Our Ref: 1160-8-25

Your Ref: Stage 3 (SSD 57703458)

**Re: Regents Park In-fill Affordable Housing – Stage 3 (SSD 57703458)
Response to submissions – Traffic.**

FIGURE 8B HRV REVERSE AND
EXIT LHT SOUTHBOUND IN RW2

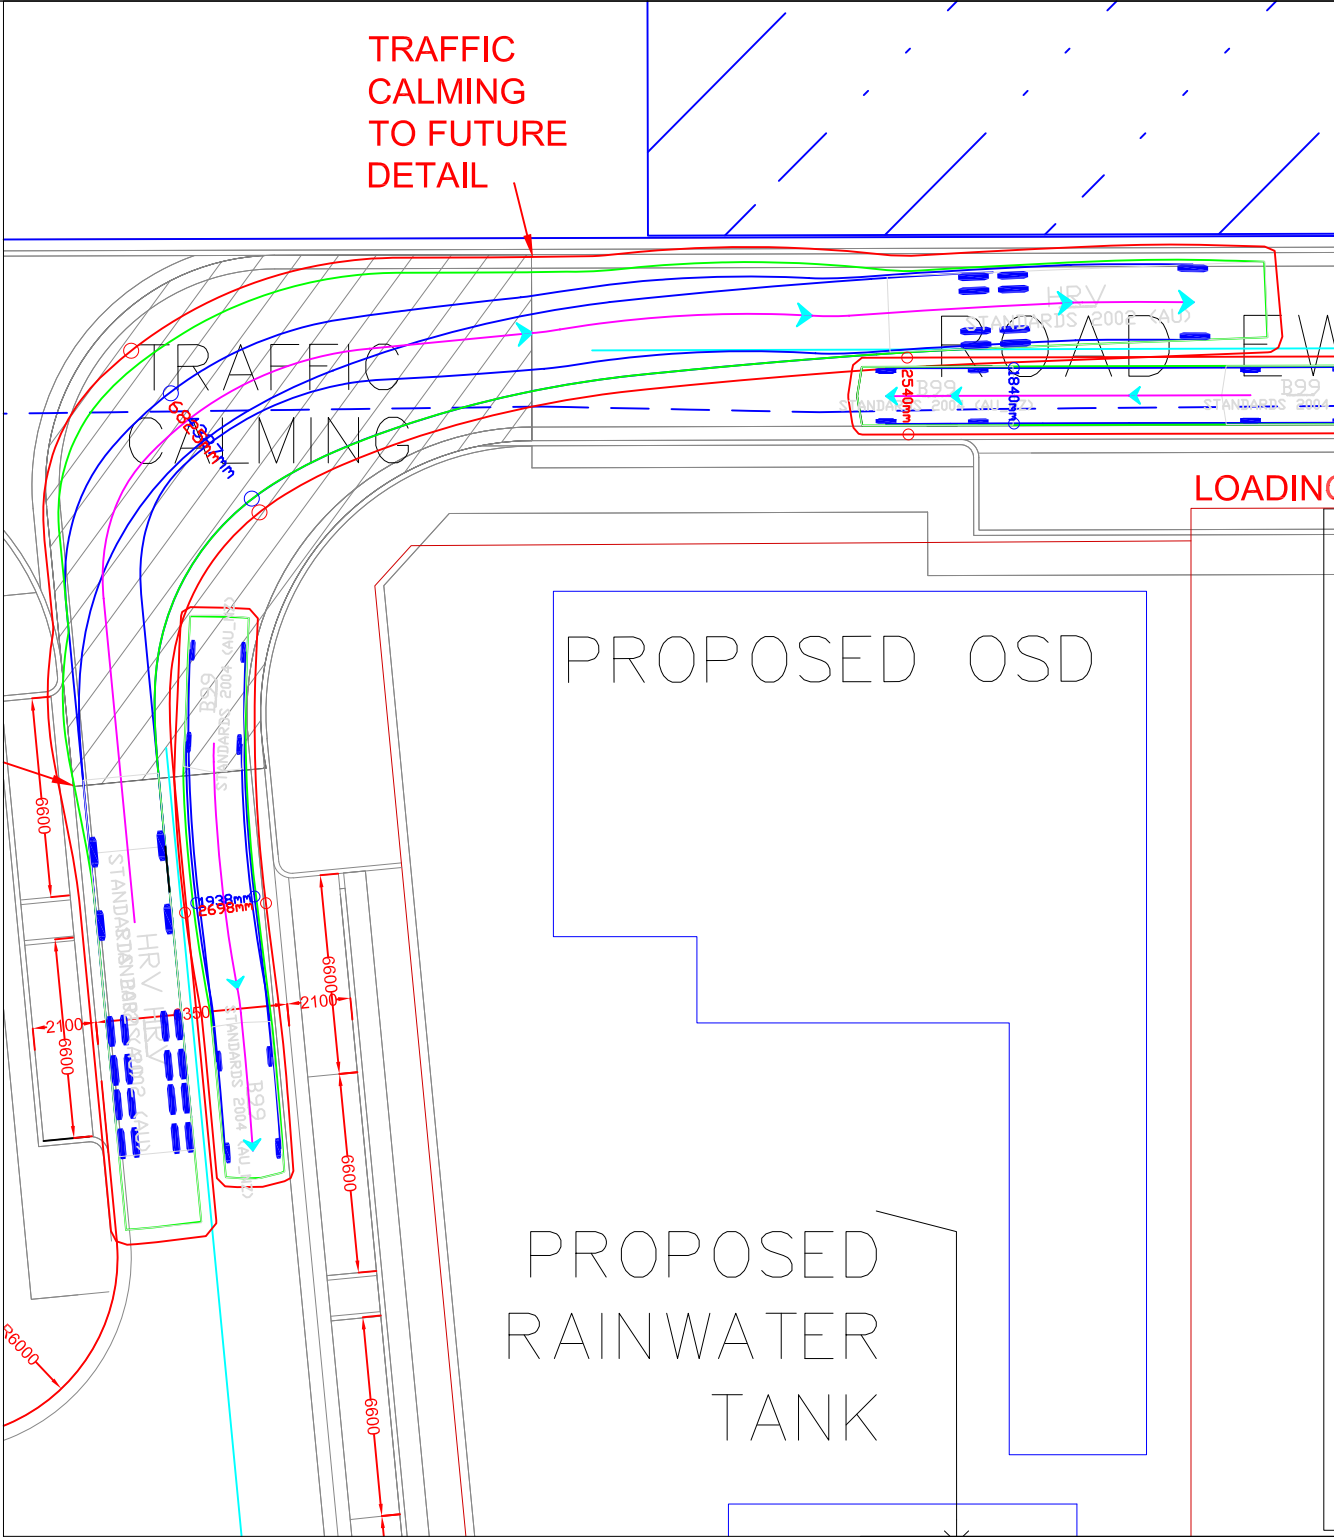
The Transport Impact Assessment and Waste Management Plan (WMP) does not provide swept paths for on-site collection by a Heavy Rigid Vehicle (HRV) or identify the travel paths from the basement waste storage to the waste collection point. The WMP advises that cleaners will be responsible for transporting waste to the collection points. Please provide:

- swept paths for waste collection vehicles
- travel path diagrams from basement waste storage to the collection point
- a designated staff room
- cleaning storage facilities.

The Transport Impact Assessment and Waste Management Plans have both been updated to include swept paths for onsite collection of waste by HRVs.
